2021/0479 Dearne Valley Parkway : Revised plans and associated documentation

This letter accompanies the revised plans submitted to form the above application following our consideration of the comments of you and your consultee colleagues. The main purpose of this letter is to set out the key changes we have made to achieve this and hopefully gain your support. These are listed below.

Unit 1 - Elevations

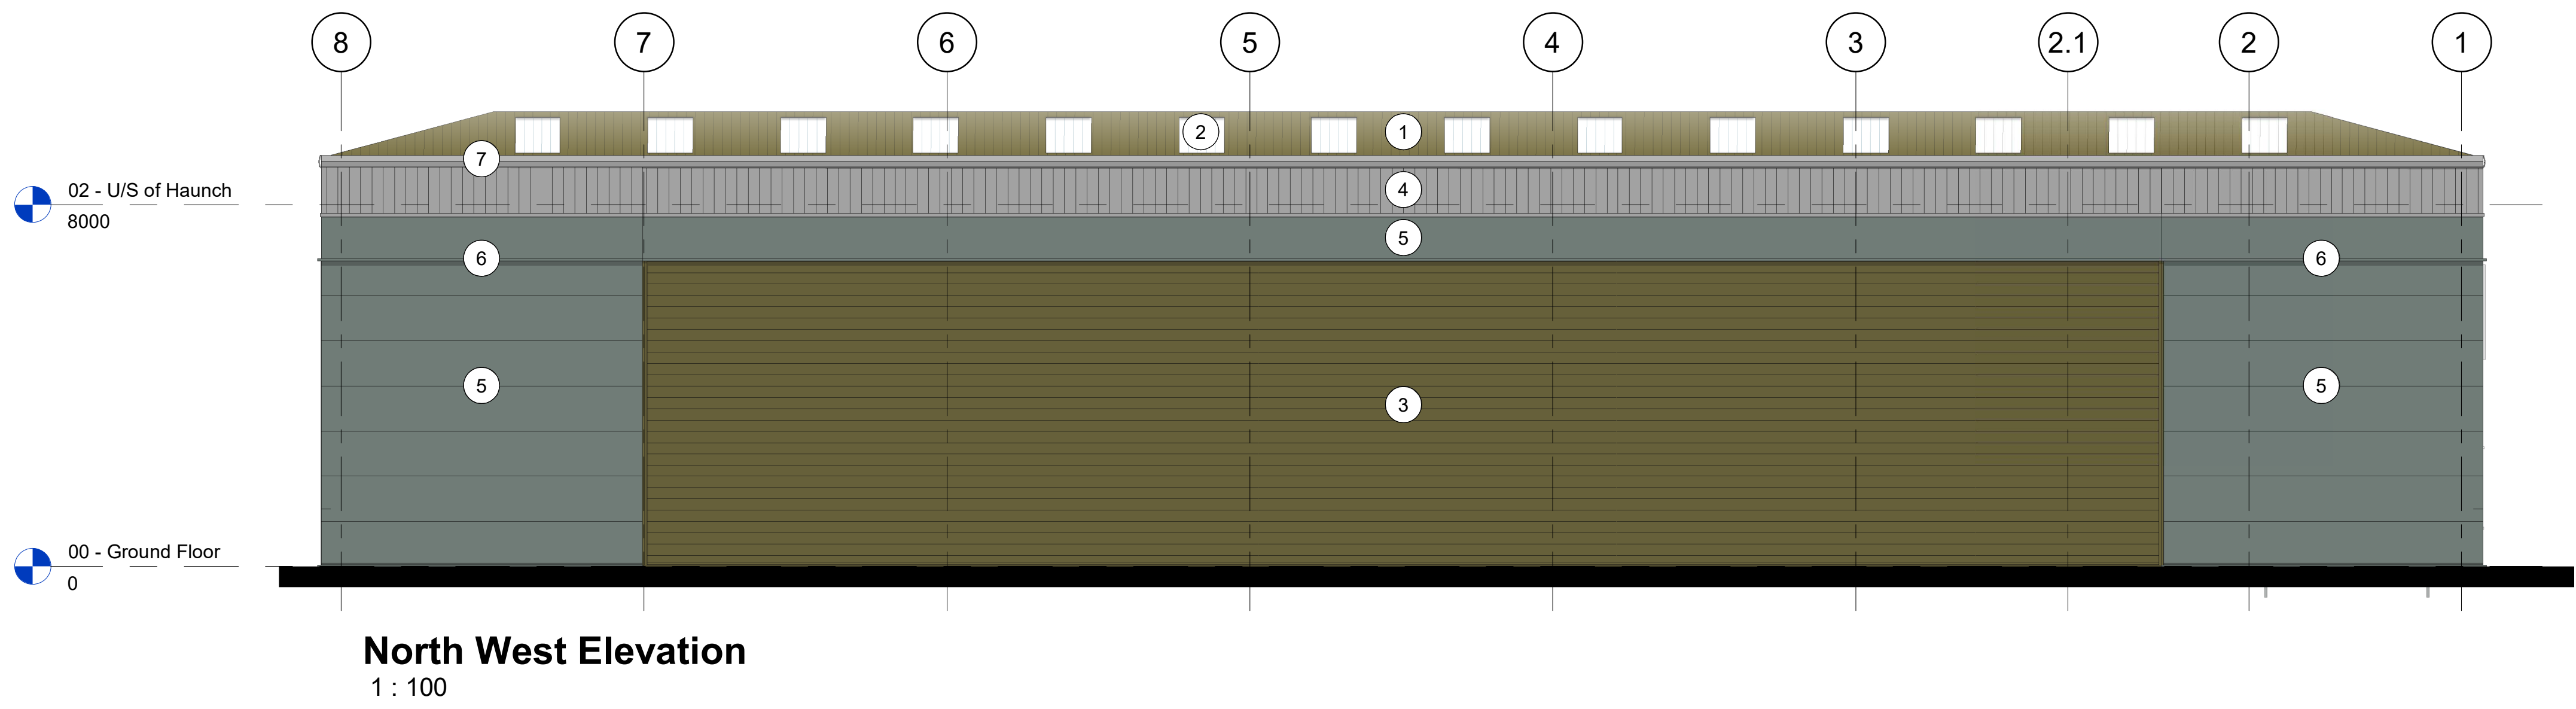
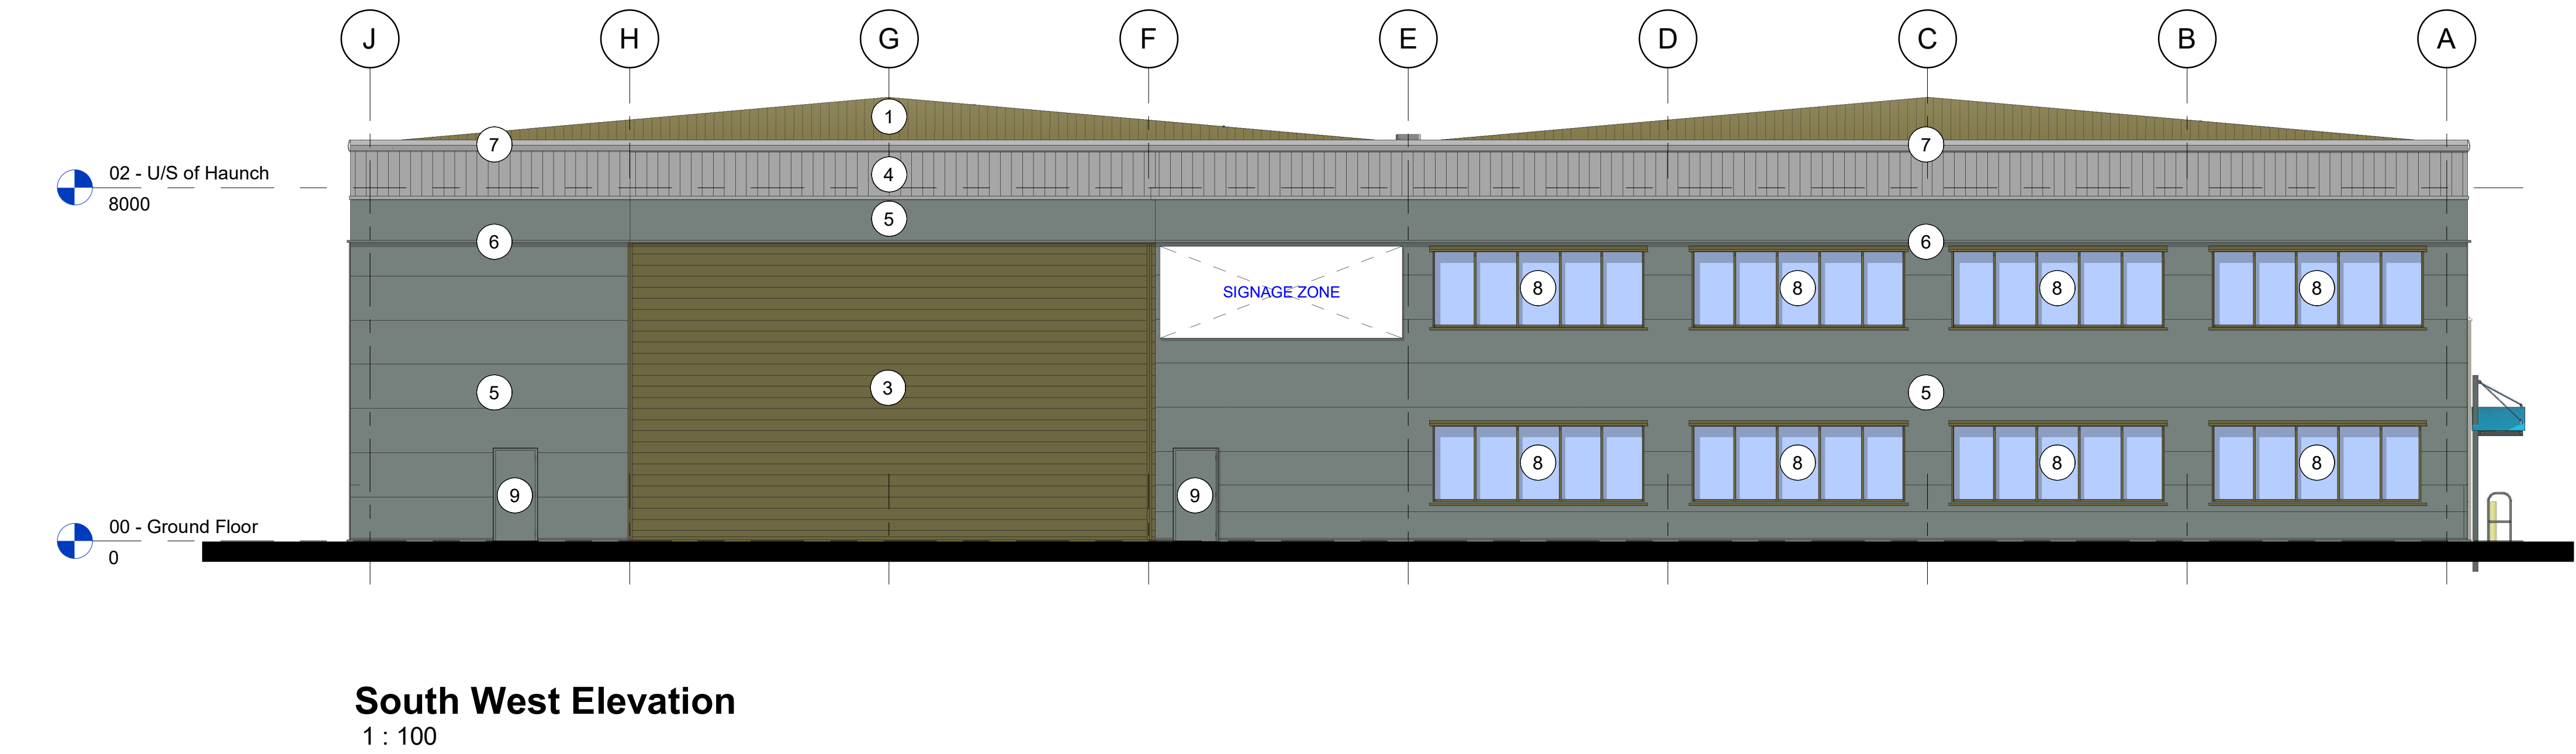
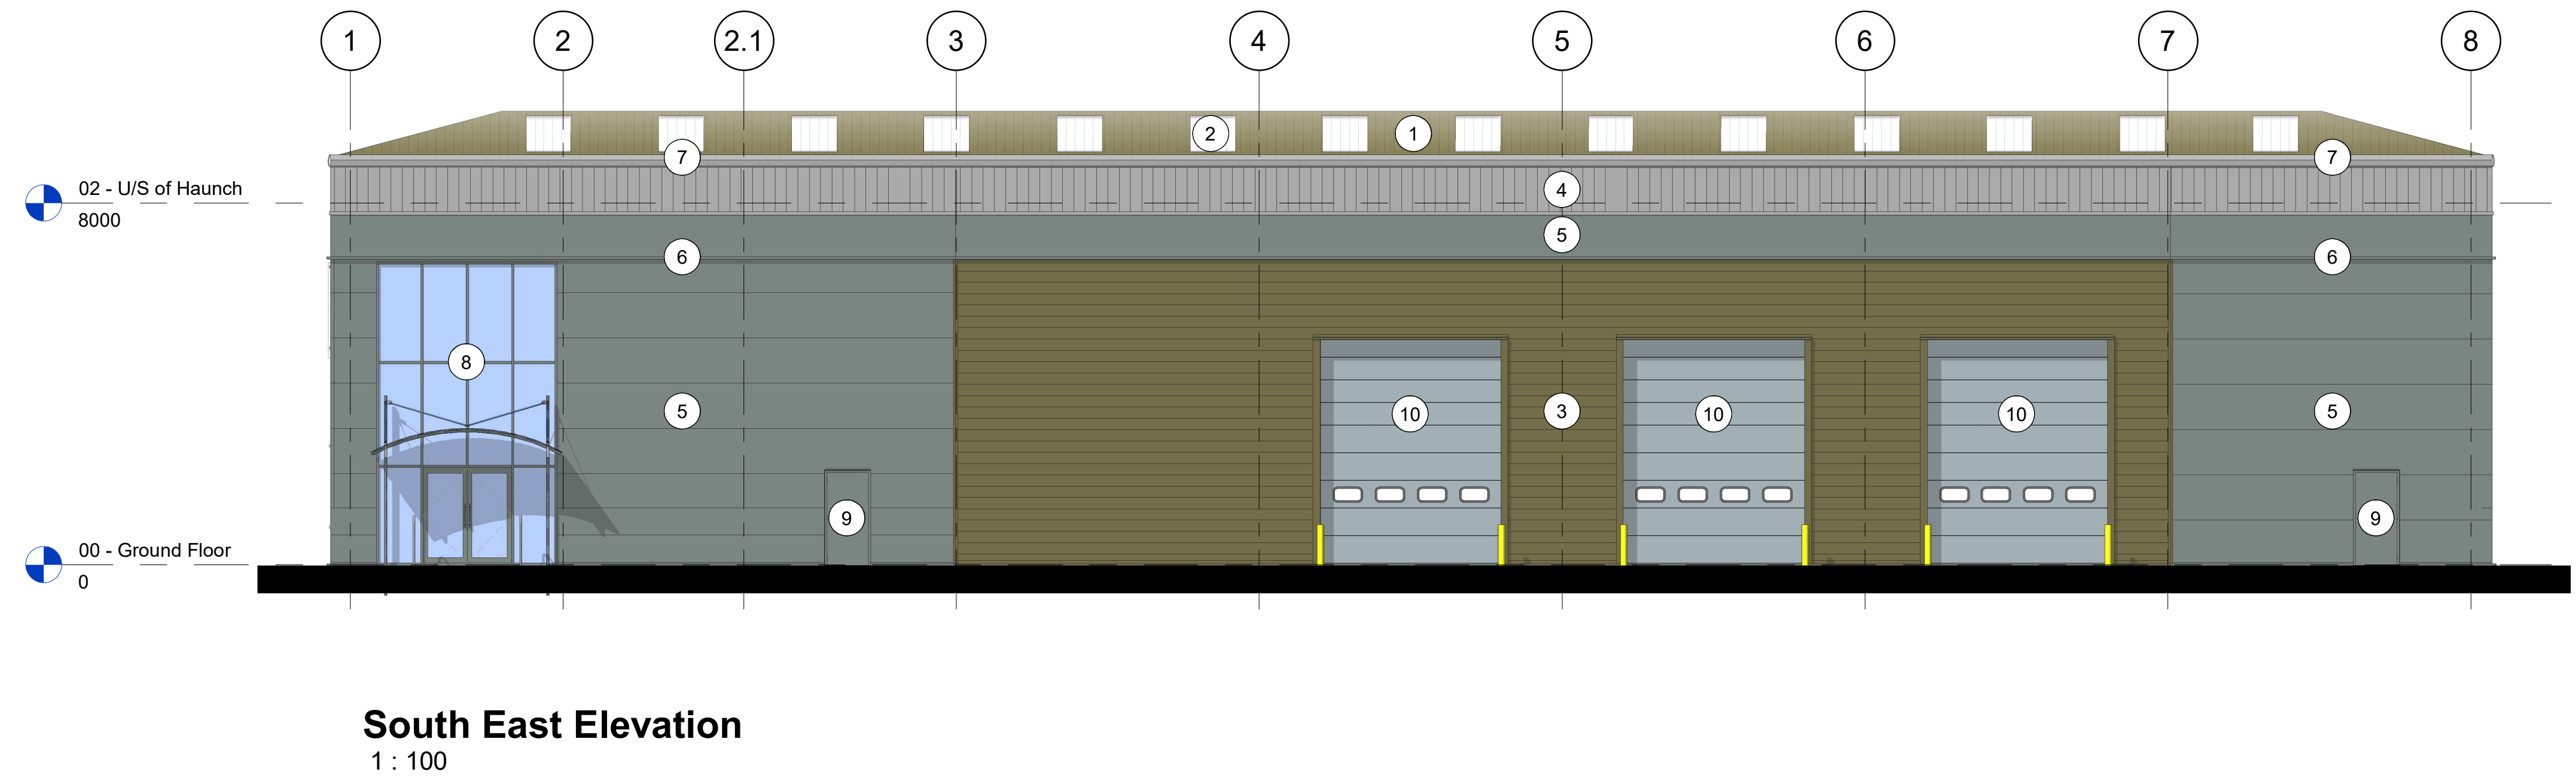
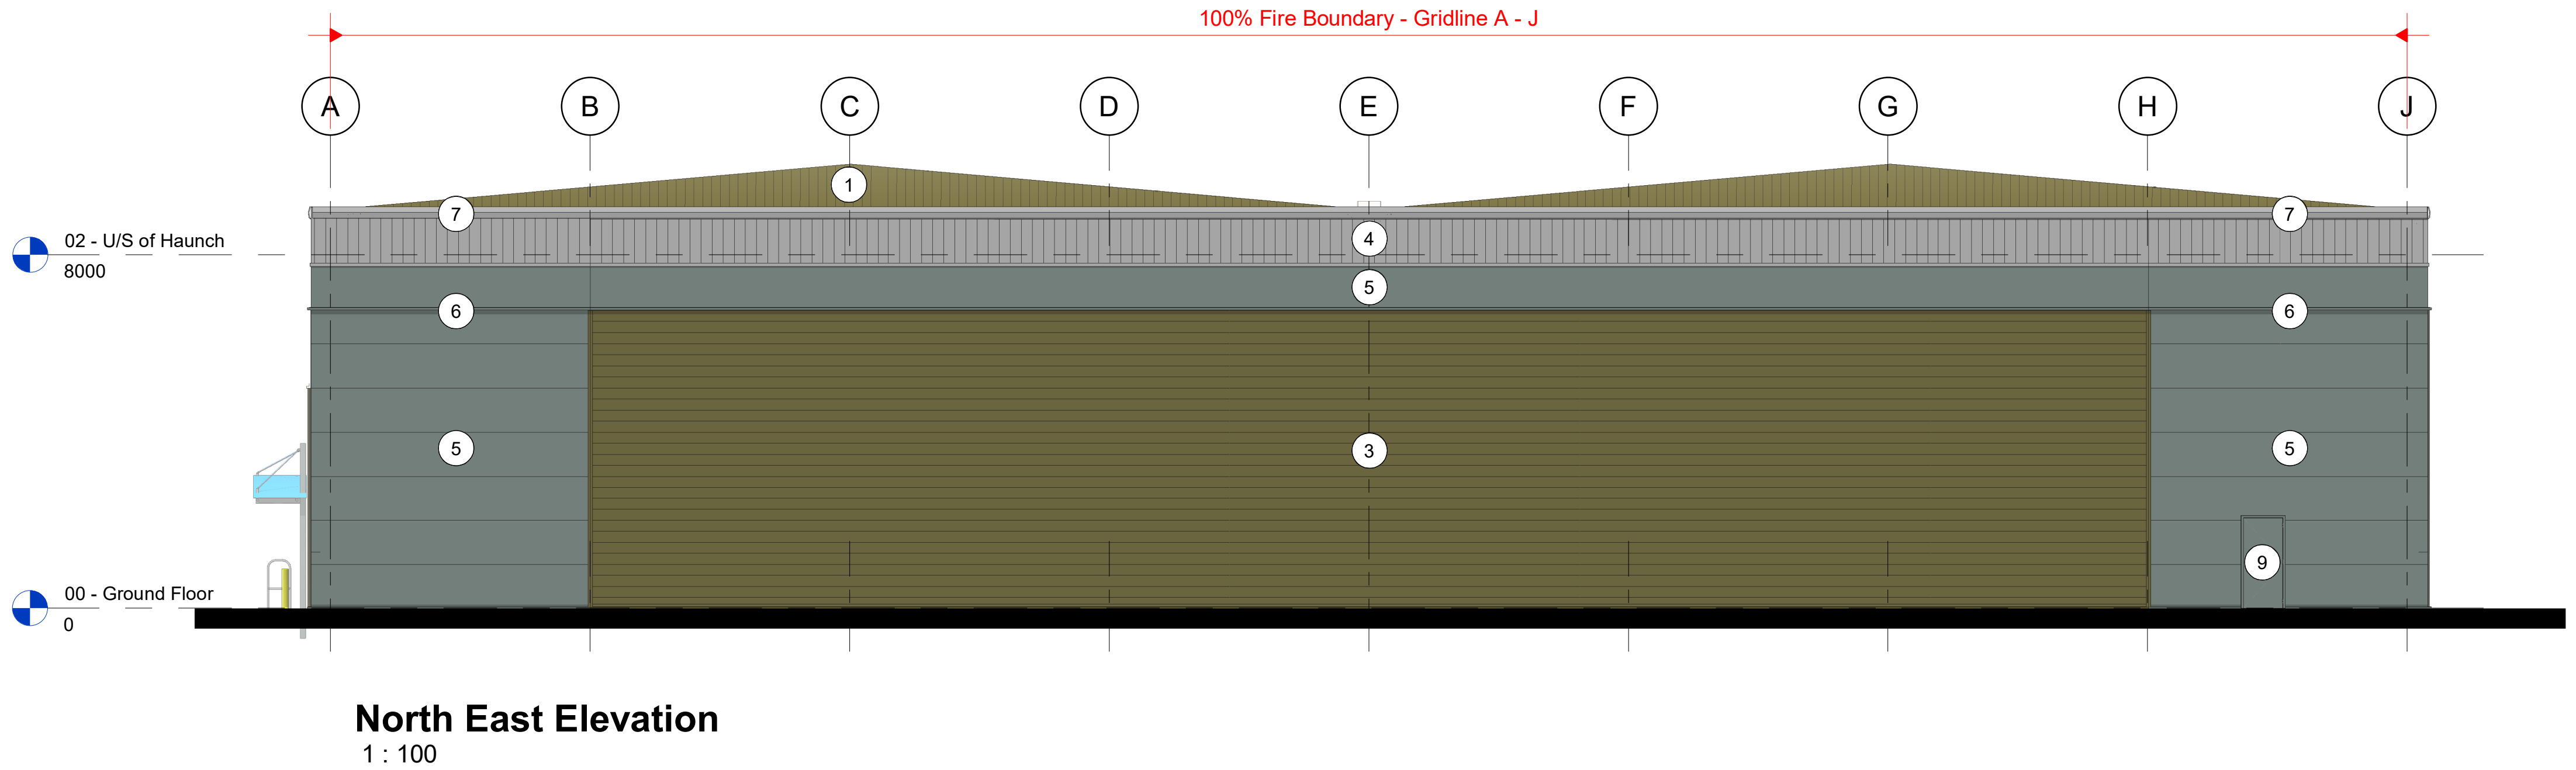
5. The offices for unit 1 have been relocated within the space available to the west within the 10metre belt and expressed externally as a distinct two storey “office block” with differing elevation treatment albeit attached to the remainder of the building.

8. The height to haunch for unit 1 has been reduced from 10metres to 8metres and a hipped roof provided to the main part of building.
9. A flat roof has been proposed for those unit 1 offices with further reduced height to parapet and a “green” roof.

17. The applicant confirms agreement to the use of the cladding colour palette contained in the masterplan and illustrated on updated drawings.

18. The new set of design drawings include hipped roofs and enhanced cladding specification around office elevations.
19. Updated site sections to demonstrate enhanced landscaping and heights of buildings in relation to that landscaping are provided.
20. A new landscape design has been prepared to accommodate layout changes and this will be used for recalculation of the BNG metric calculation to be submitted separately.
21. The Masterplan includes a table in Section 6 which sets out the areas and proportion of site expected to be utilised by specified land uses. The relevant areas in the application proposals have been measured and a combined table is included below.
